Application by Awel y Môr Offshore Wind Farm Limited for an Order Granting Development Consent for the Awel y Môr Offshore Wind Farm project

The Examining Authority's written questions and requests for information (ExQ1) Issued on 27 September 2022

Esri UK, Esri, HERE, Garmin, INCREMENT P, USGS

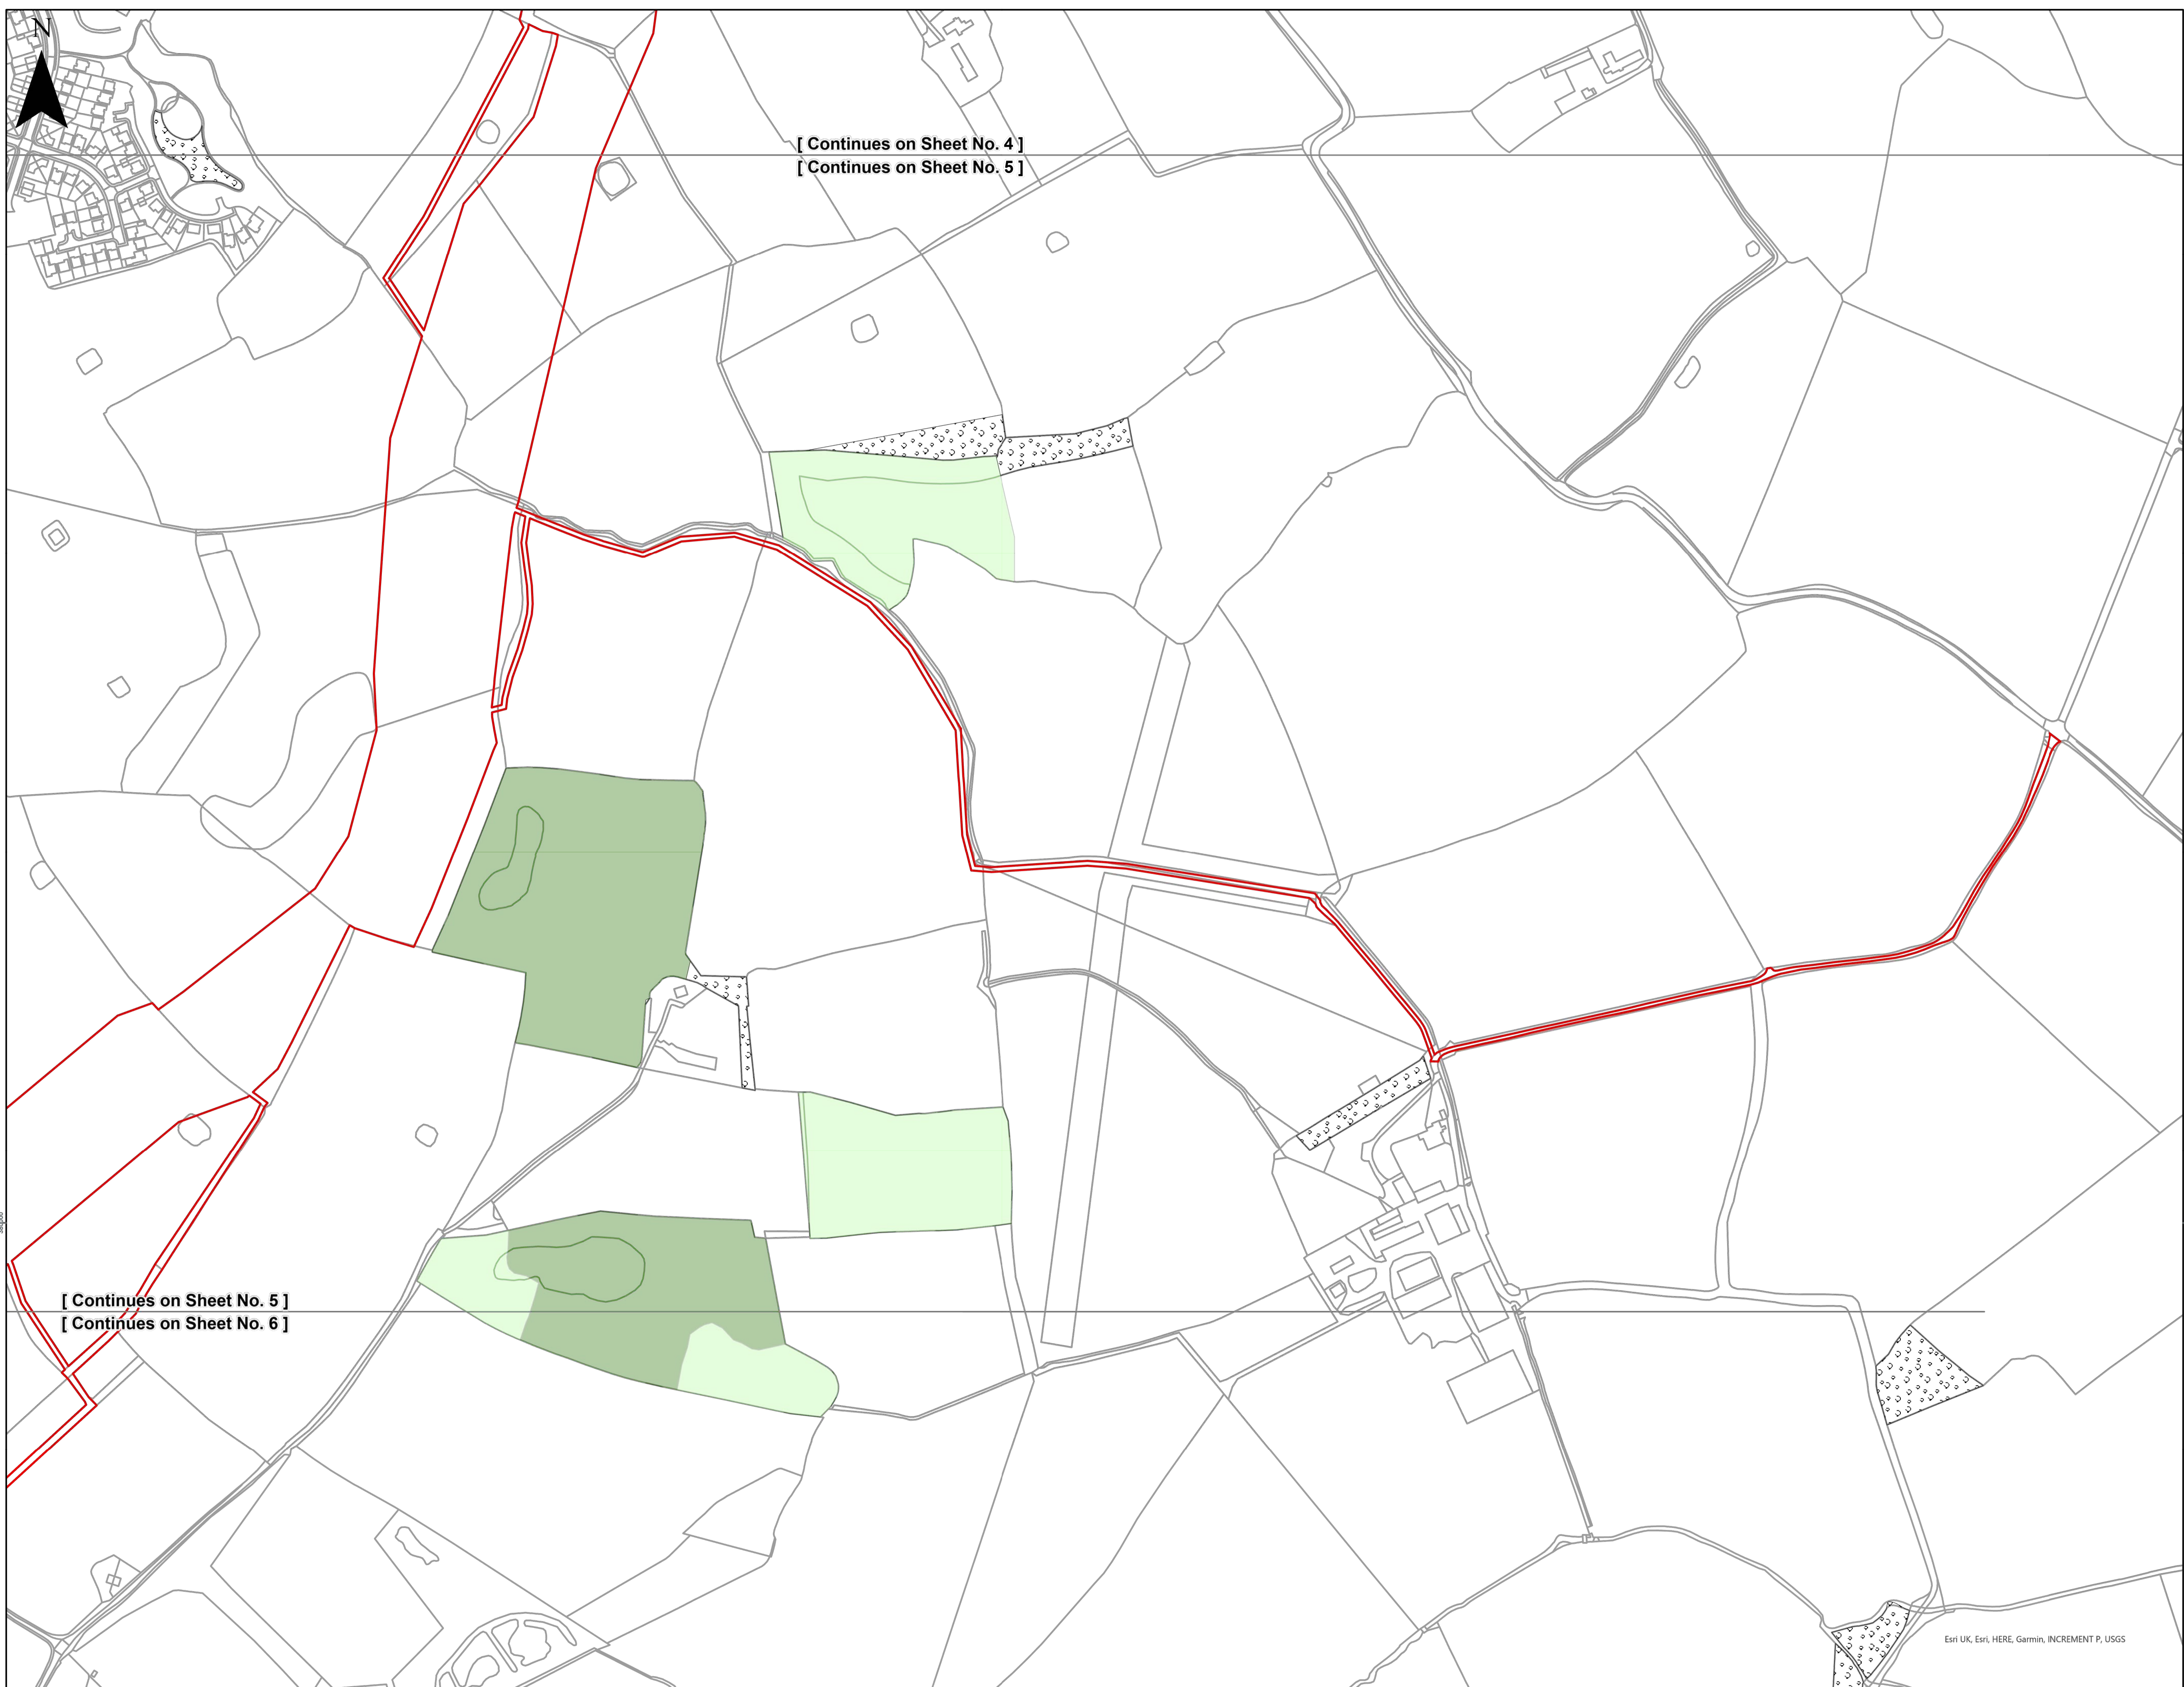
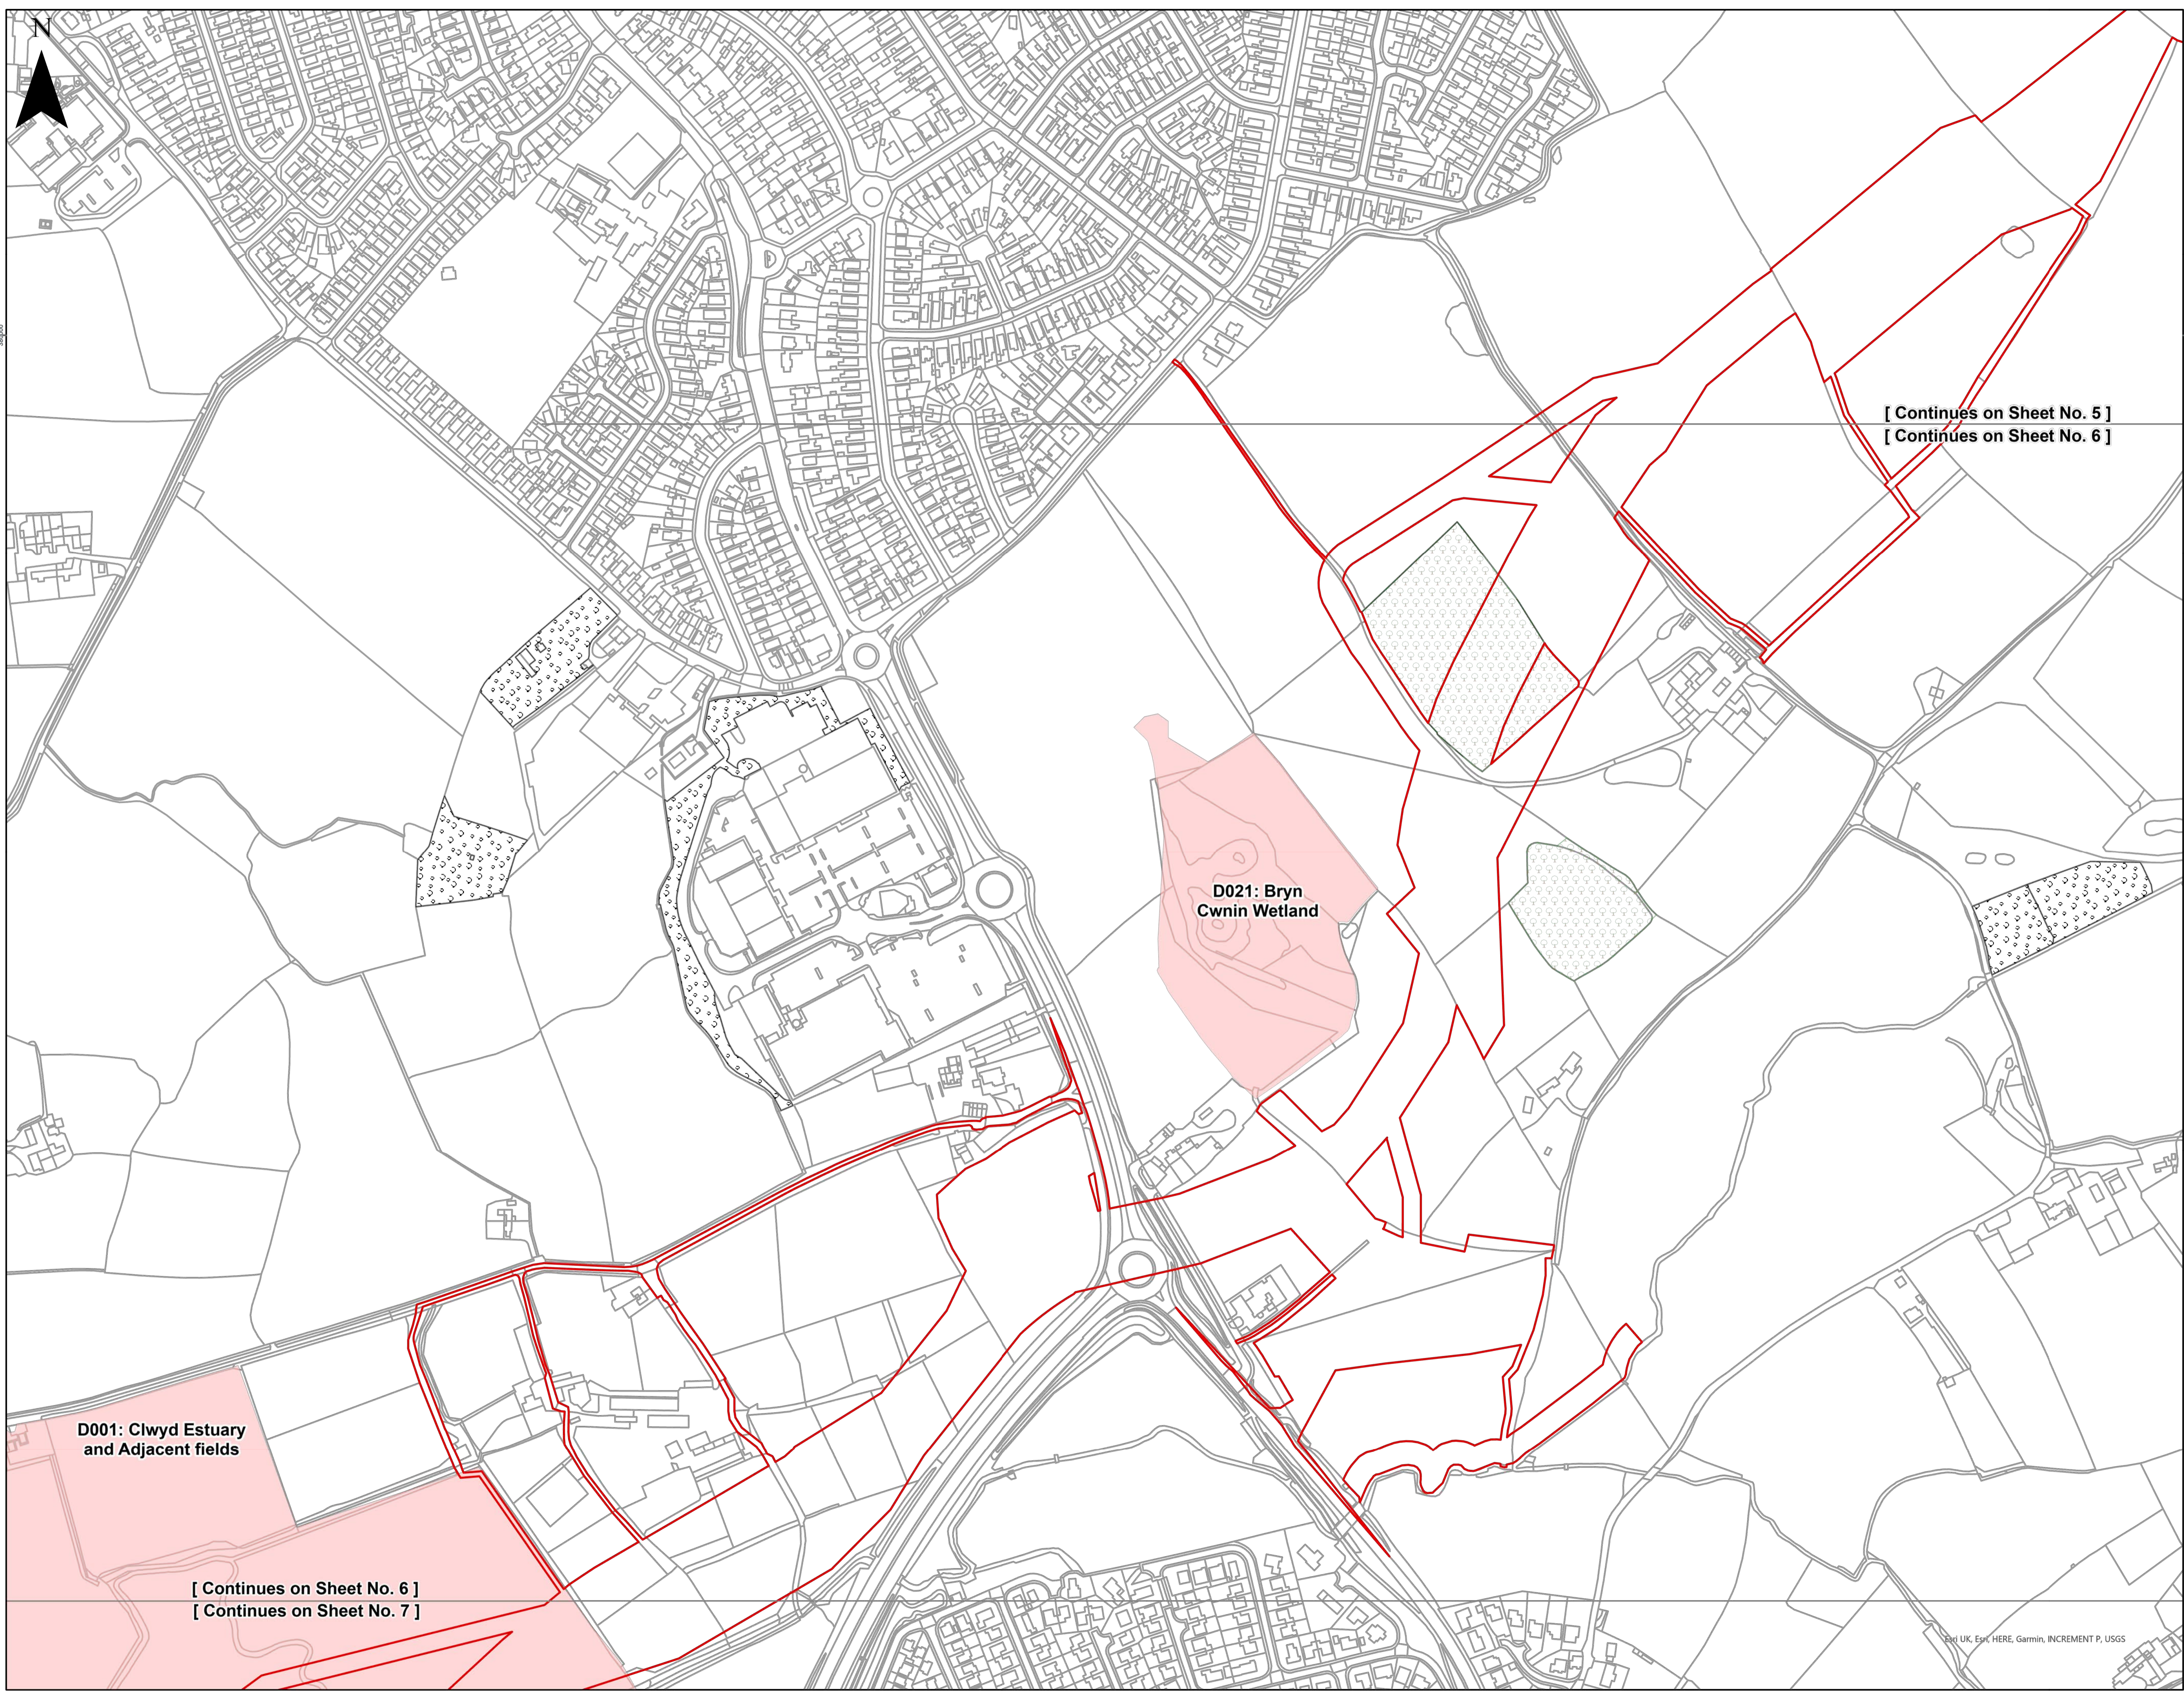
2.7	The Applicant	<p>General Statutory / Non-statutory Nature Conservation Sites Plan [AS-010] Please can you address the following points:</p> <ul style="list-style-type: none">a) Sheet 1 of 11 - The legend does not reflect all hatch colours shown and the extents of SPA hatch appears to be different on sheets 2 and 3;b) Sheet 2 of 11 –does the drawn shape and extent of Local Wildlife Sites at western edge reflects y Ffrith D011;c) differentiate the woodland area to help identify other ancient semi-natural woodland, plantation on ancient woodland site and local other woodland;d) label the name of the other nature reserves on the relevant sheet.
